Ribble Valley Borough Council
Housing & Development Control

Application no: **3/2022/0632**

Address: **Pendle Mill Pendle Road Clitheroe BB7 1JQ**

Proposal: **Demolition of existing buildings and erection of a care home (Use Class C2) of up to 70 beds. All matters reserved apart from access.**

Drawing Title
Existing and Proposed Site Section C-C

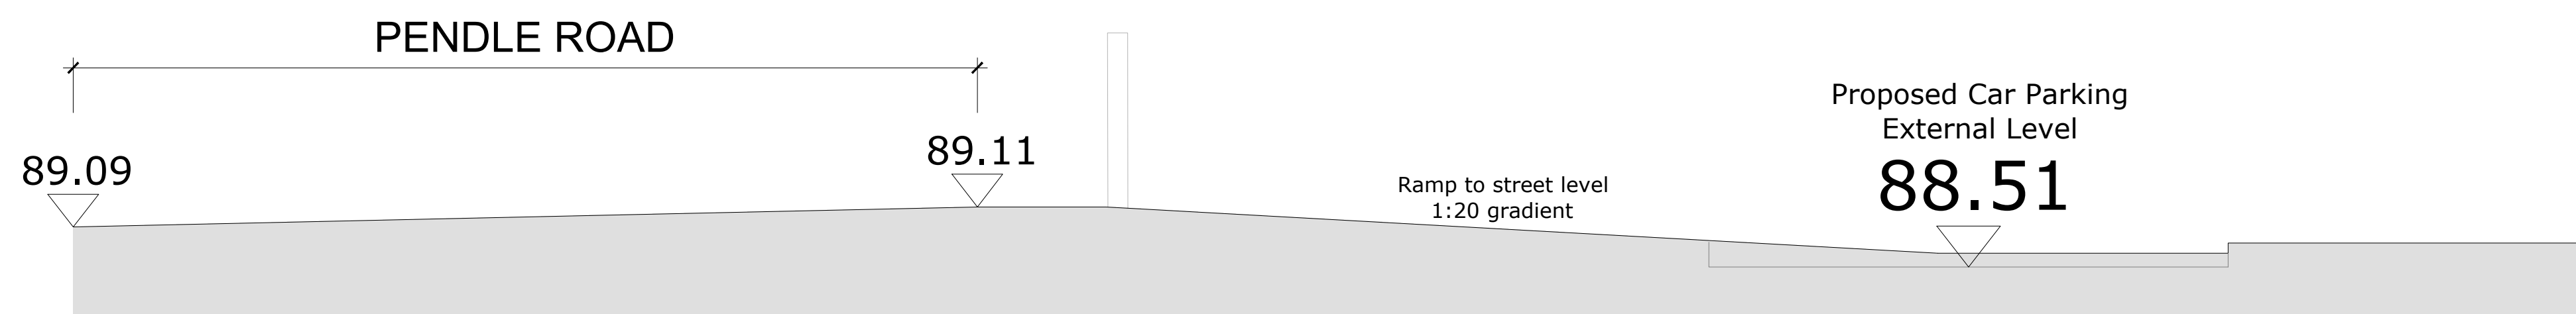
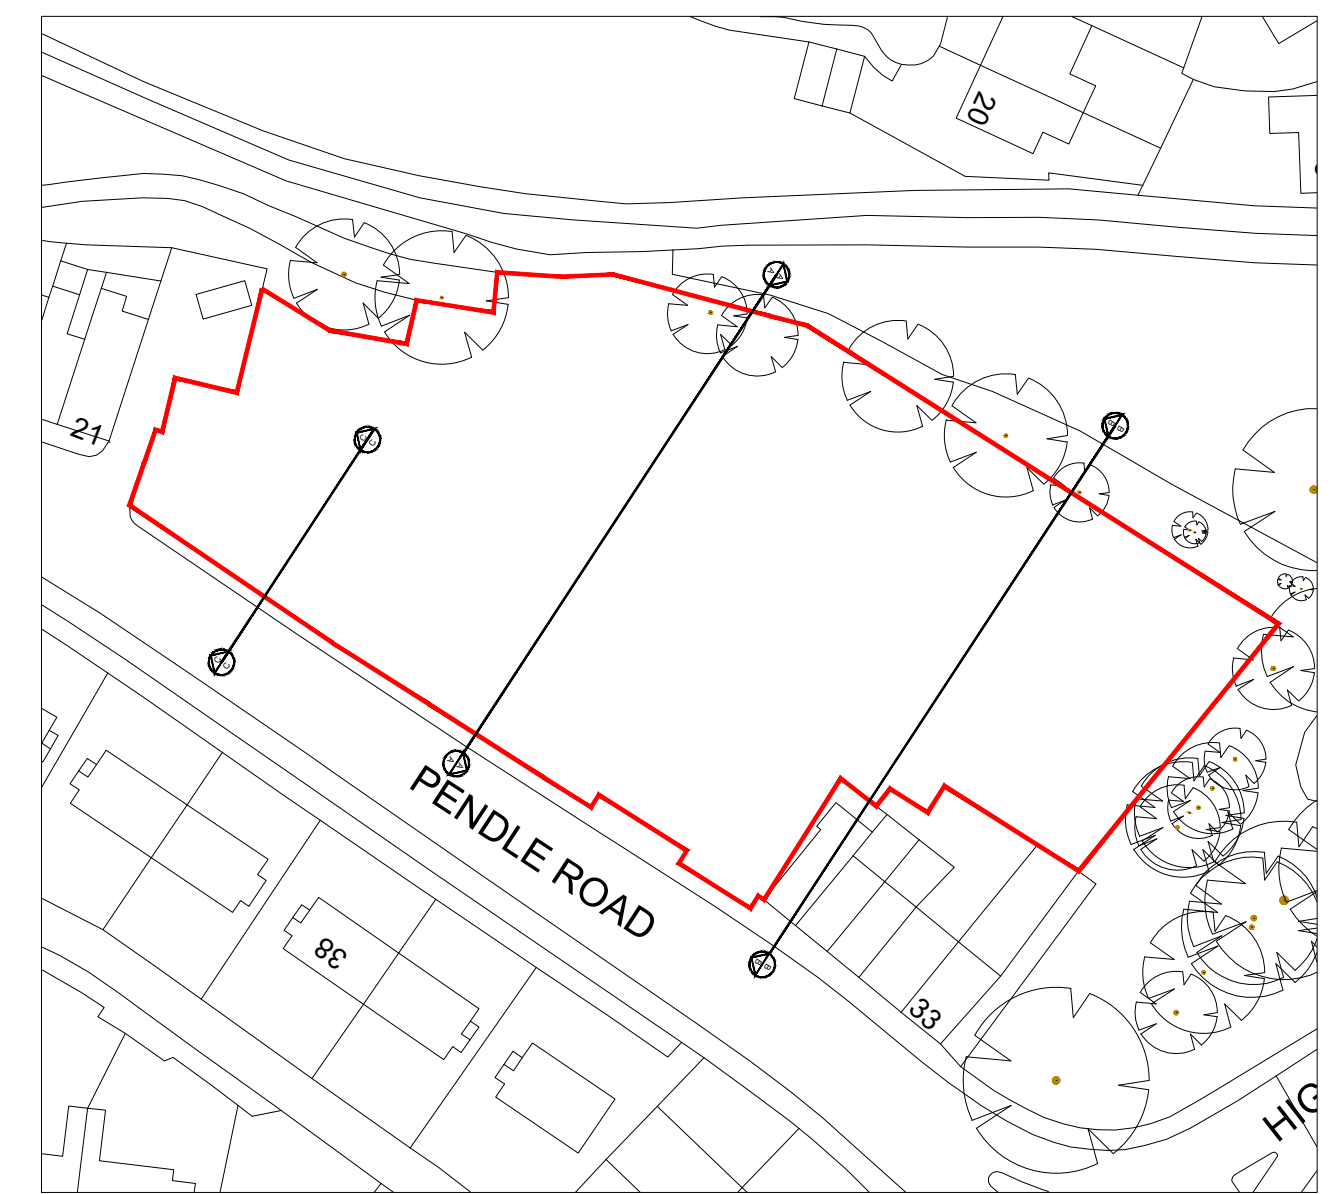
Before reviewing the technical details of the proposed access, the LHA are aware by visiting the site and by reviewing Google Streetview that there is a level difference at the proposed site access between the highway and the internal road network. The LHA have reviewed the Muller drawing number (9-) 22 titled "Existing and Proposed Site Section C-C" and are aware that the level difference between the adopted highway and the proposed access will be no greater than 1 in 20, which complies with the LHAs guidance.

However, to erect the access, the retaining wall structure located at the back of the existing footway fronting Pendle Road will need to be altered. The LHA inform the Agent and Applicant that any change to this feature will need a technical drawing to be submitted to ensure that any change will not destabilise the adopted highway. This will be conditioned below.

3. No development shall take place until an Approval In Principle (AiP) Structural Report setting out how any structures within 6 metres of the edge of the adopted highway (and outside of this measure where the failure of any structures would affect the safety of road users) will be assessed, excavated, constructed, strengthened or demolished has been submitted to and approved in writing by the Local Planning Authority.

Drawing Title
 Proposed Site Plan with Culvert and Trees

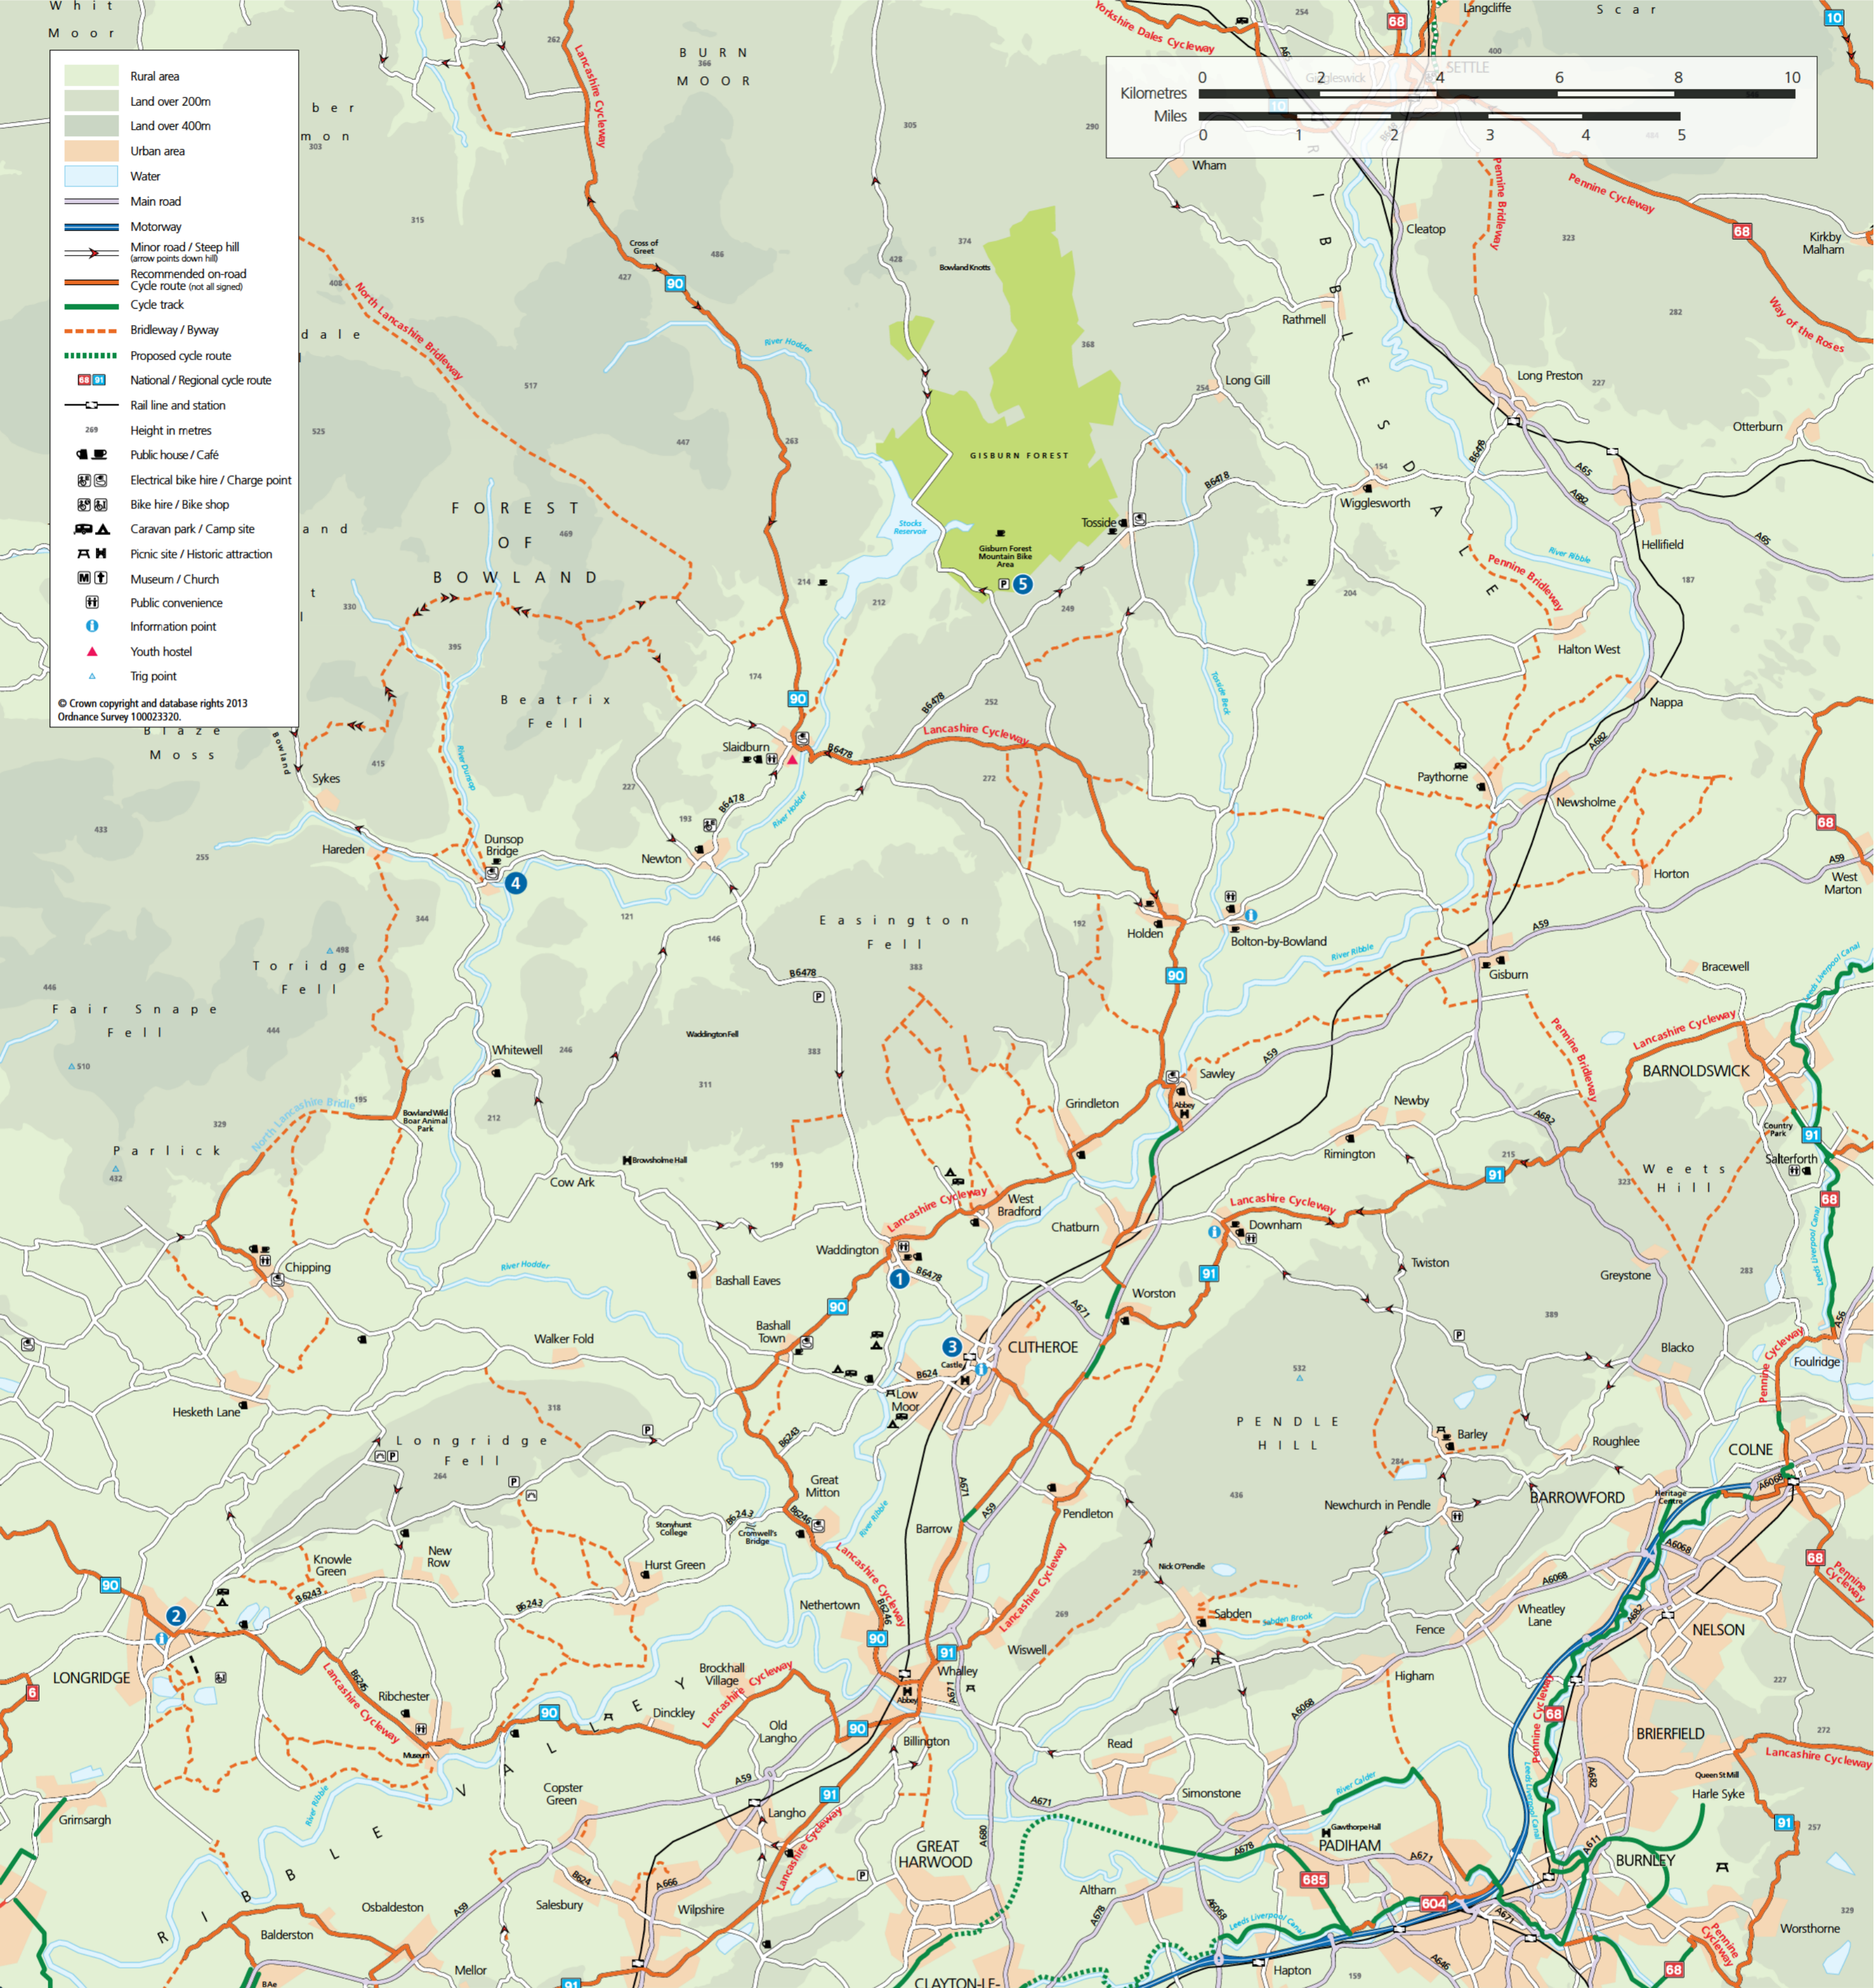
However, the LHA have reviewed Sanderson drawing number 300828-001 Rev B titled "Proposed Access Arrangement and Visibility Splays," and are aware that the site will provide 28 car parking spaces for the site, including two disabled bays and 3 Electric Vehicle charging points.

The LHA also inform the Agent that during the reserved matters stage, that the LHA will request that cycle storage facilities are provided to encourage sustainable travel and that a drawing should be provided to show where the bin collection points will be located internally.
